Office of
Environment
& Heritage

DOC18/908962
SSD 8865

Notice of Exhibition – Concept Proposal for Redevelopment of St Anthony of Padua Catholic School (SSD 8865)

Attachment 1 – OEH comments on Concept Proposal for Redevelopment of St Anthony of Padua Catholic School (SSD 8865)

FIGURE 4
CATHOLIC SCHOOL DEVELOPMENT
EXISTING CASE
PMF PEAK FLOOD LEVELS & DEPTHS

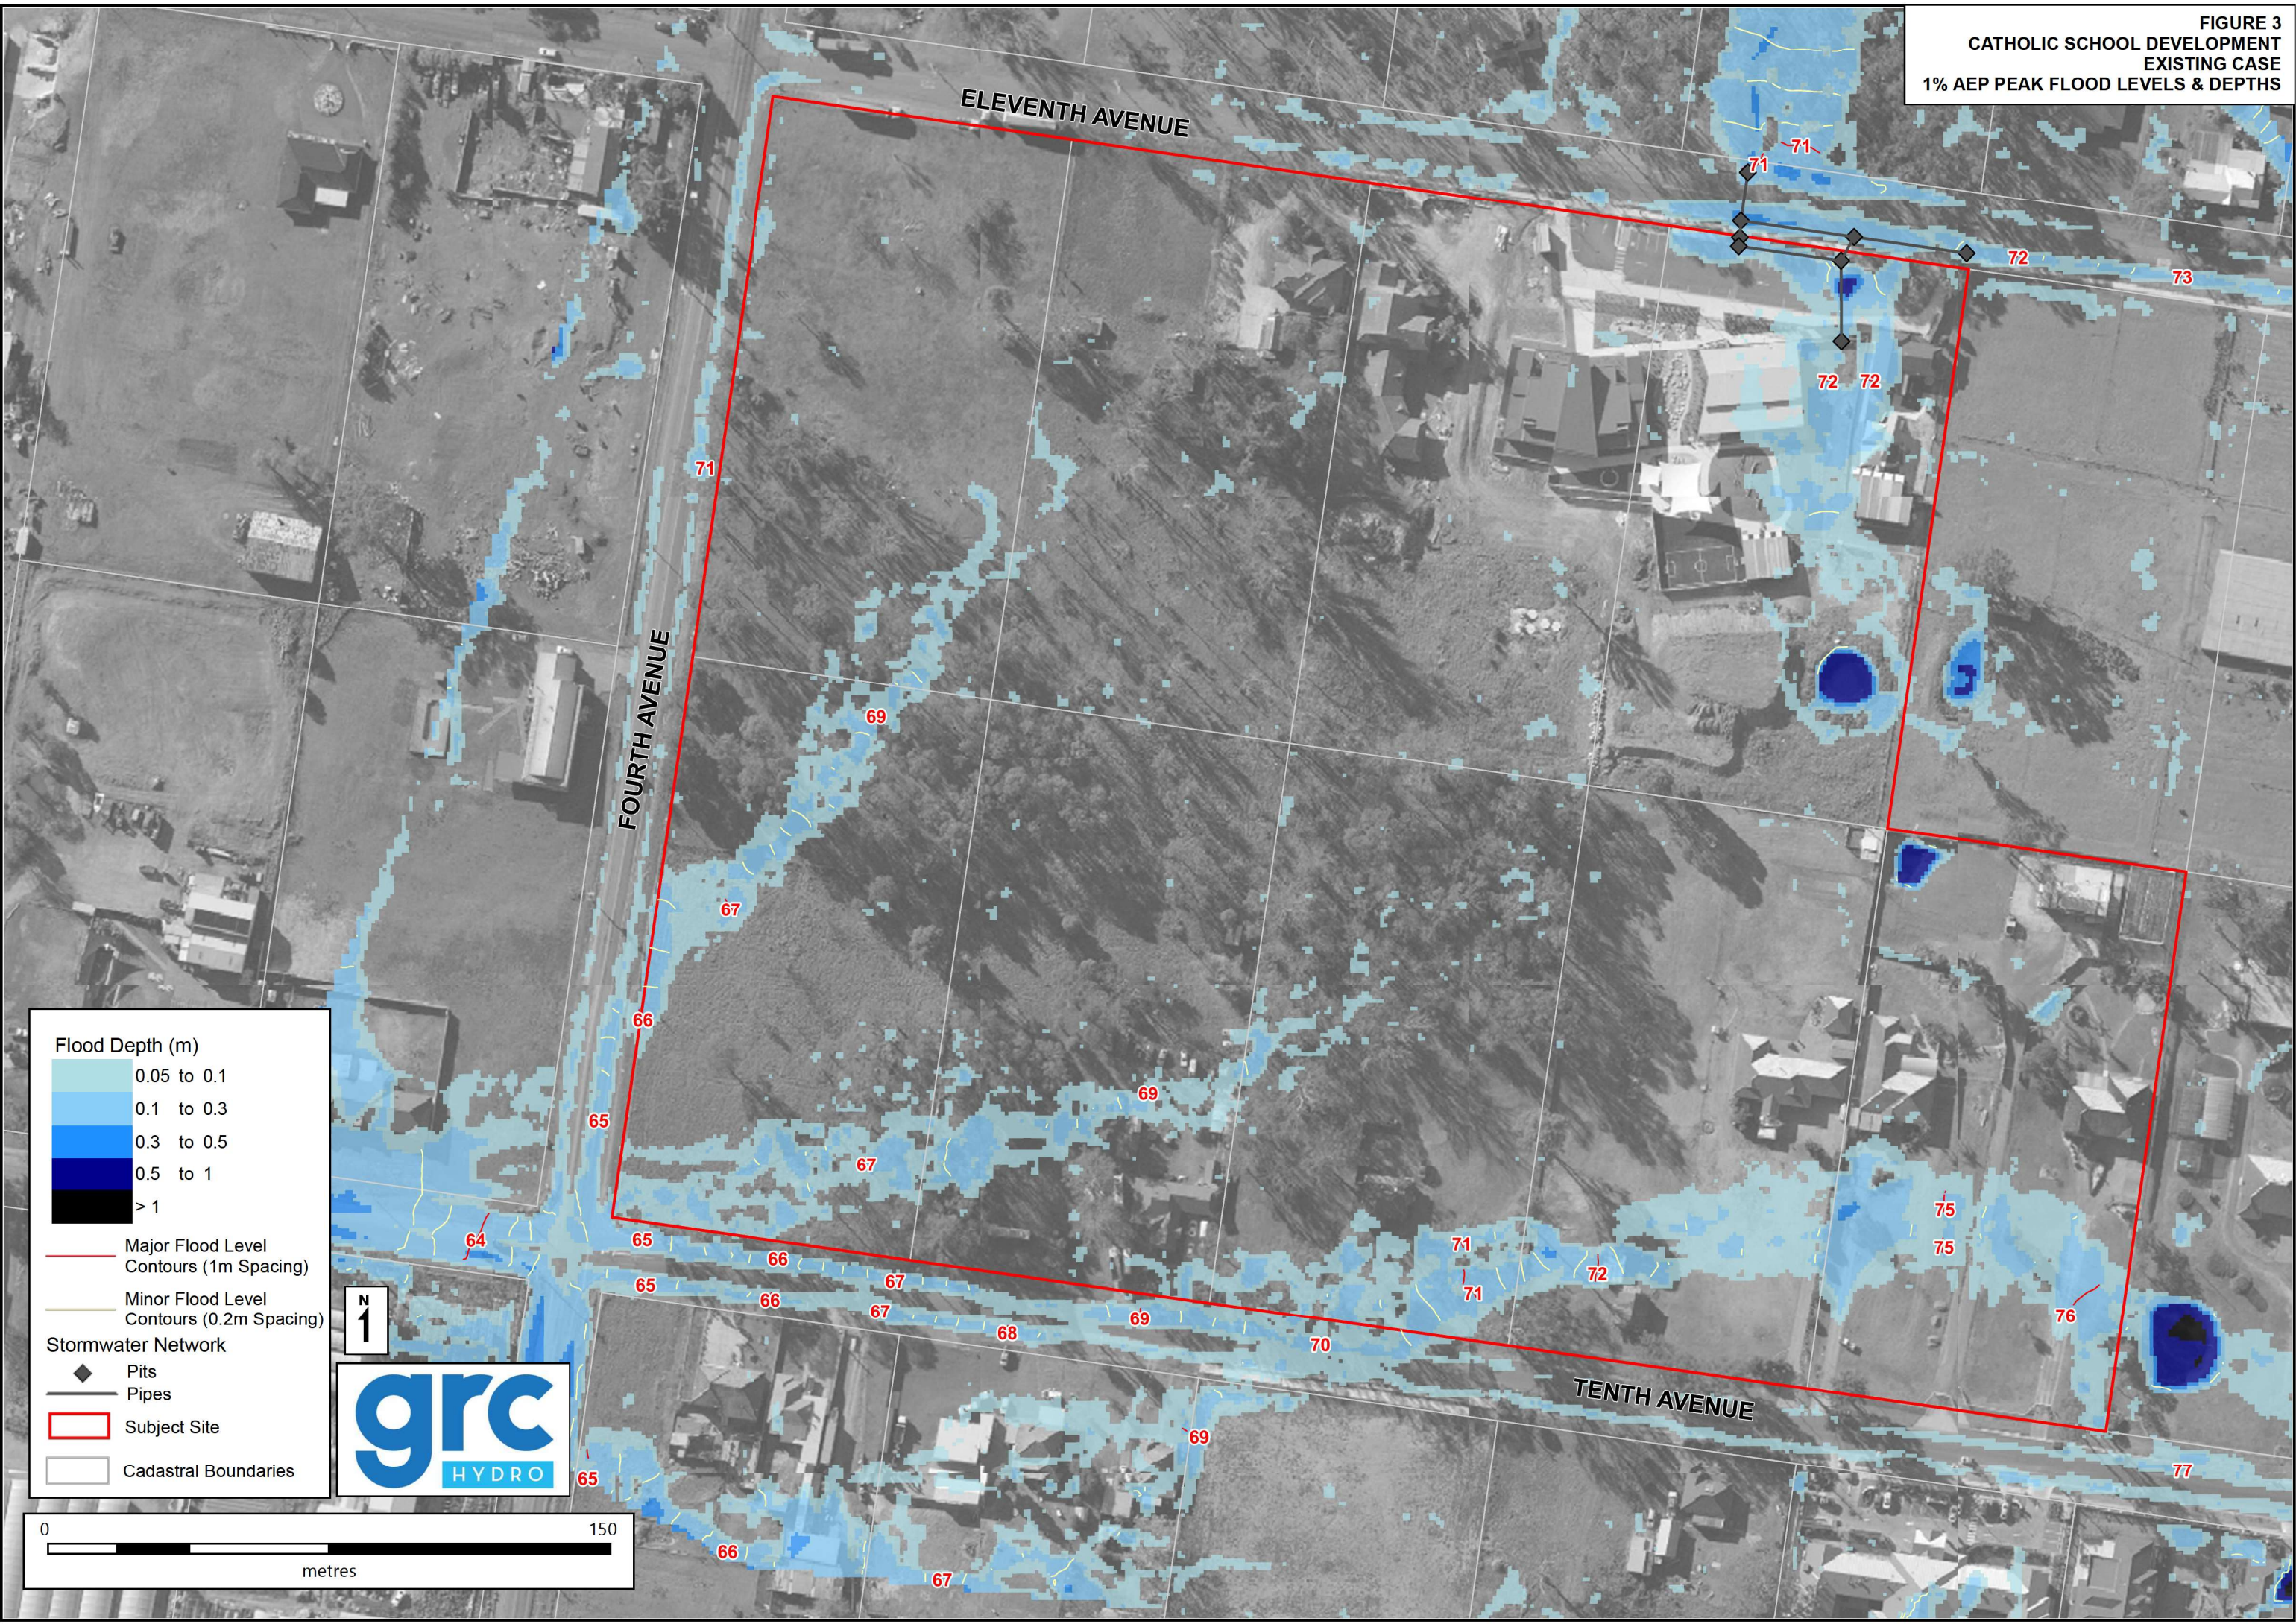
- The flood maps (grc Hydro, July 2018) included in Appendix R (Part 2) appear to have inconsistencies between the existing conditions and the proposed development conditions. Figure 4 for the existing conditions shows minor flood affectation in the 1% AEP at the southern end of the development site (i.e. Tenth Avenue), while Figure 5 shows widespread flooding across the site particularly across the south west and southern areas. Also, the flood maps under developed scenarios do not show any flood affectation at these locations. These inconsistencies need to be checked, corrected and updated in the report in order to have sound understanding of flood behaviour within the site for the proposed development.
